From: Martyn White
Sent: 13 August 2019 13:50
To: Planning.Responses <Planning.Responses@arun.gov.uk>
Cc: Amber Willard <Amber.Willard@arun.gov.uk>
Subject: AW/184/19/HH & AW/185/19/L

AW/184/19/HH & AW/185/19/L

149 Barrack Lane is a Grade II Listed Building. It was previously part of a larger house but was created when that building was subdivided into two smaller properties at some point in the C.20.

DRAWING TITLE
LOCATION PLAN, BLOCK PLAN AND SITE PLAN

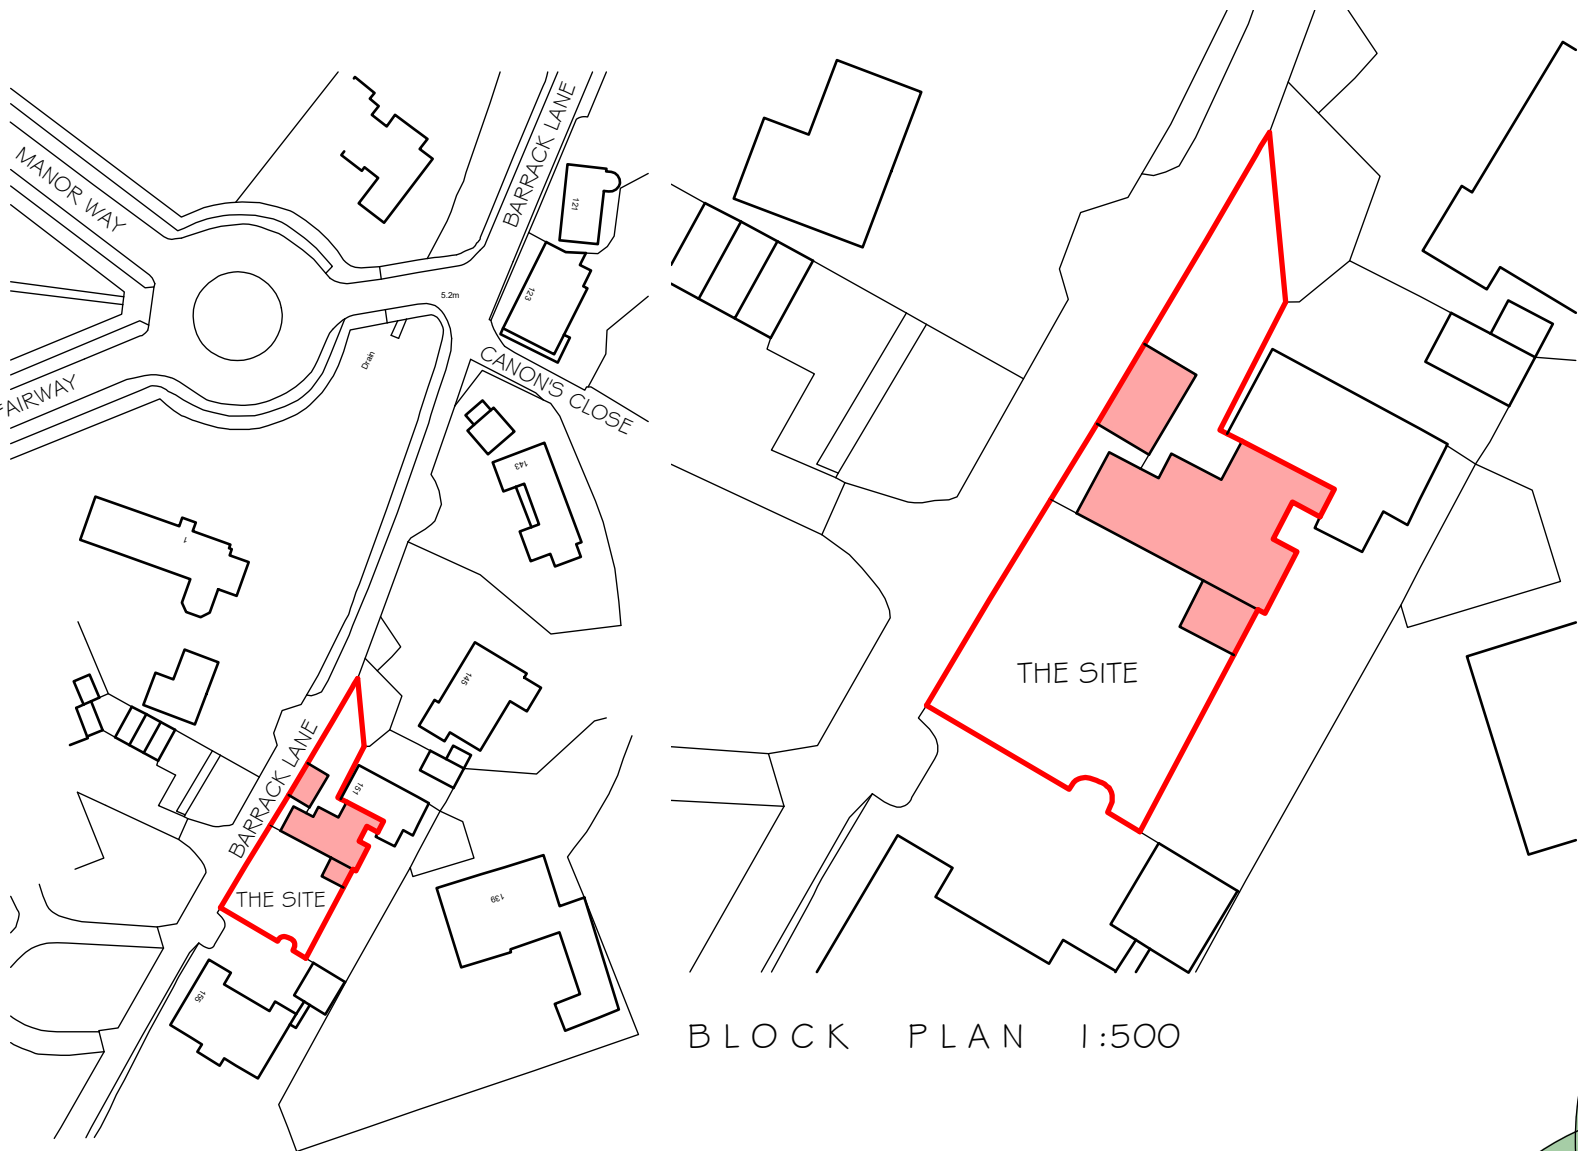
The two extensions to the building are small scale in appearance, with the proposed covered passage/storage area utilising an existing area between the house and the existing boundary wall. The flat roofed element should be subservient to the listed building and not visible from the carriageway. It is suggested that the roof should not overhang the existing wall in any way.

It will be important to ensure that this element of the works will not harm the boundary wall which is not only part of the curtilage of the listed building, but also an important part of the street-scene. You may wish to request details of how the wall will be protected as part of the proposals.

Likewise, the proposed porch extension appears to be small in scale and reflects the established character of the building. The concept of a pitched roof to the existing garage is positive as it will ensure that it is better reflects the character of the listed building.

Works which replace the modern glazing system on the conservatory roof will be an enhancement to the building. Works to the rough cast render should match existing, including the existing colour and texture. It is also considered that the works to windows WF05. 06 07 and 08 and DG08 will have a neutral impact, subject to details.

The new out building is located to the rear of the garden, and adjacent to a neighbouring garden structure. It is considered that its location, design and the fact that it screens a neighbouring structure means that it is acceptable.
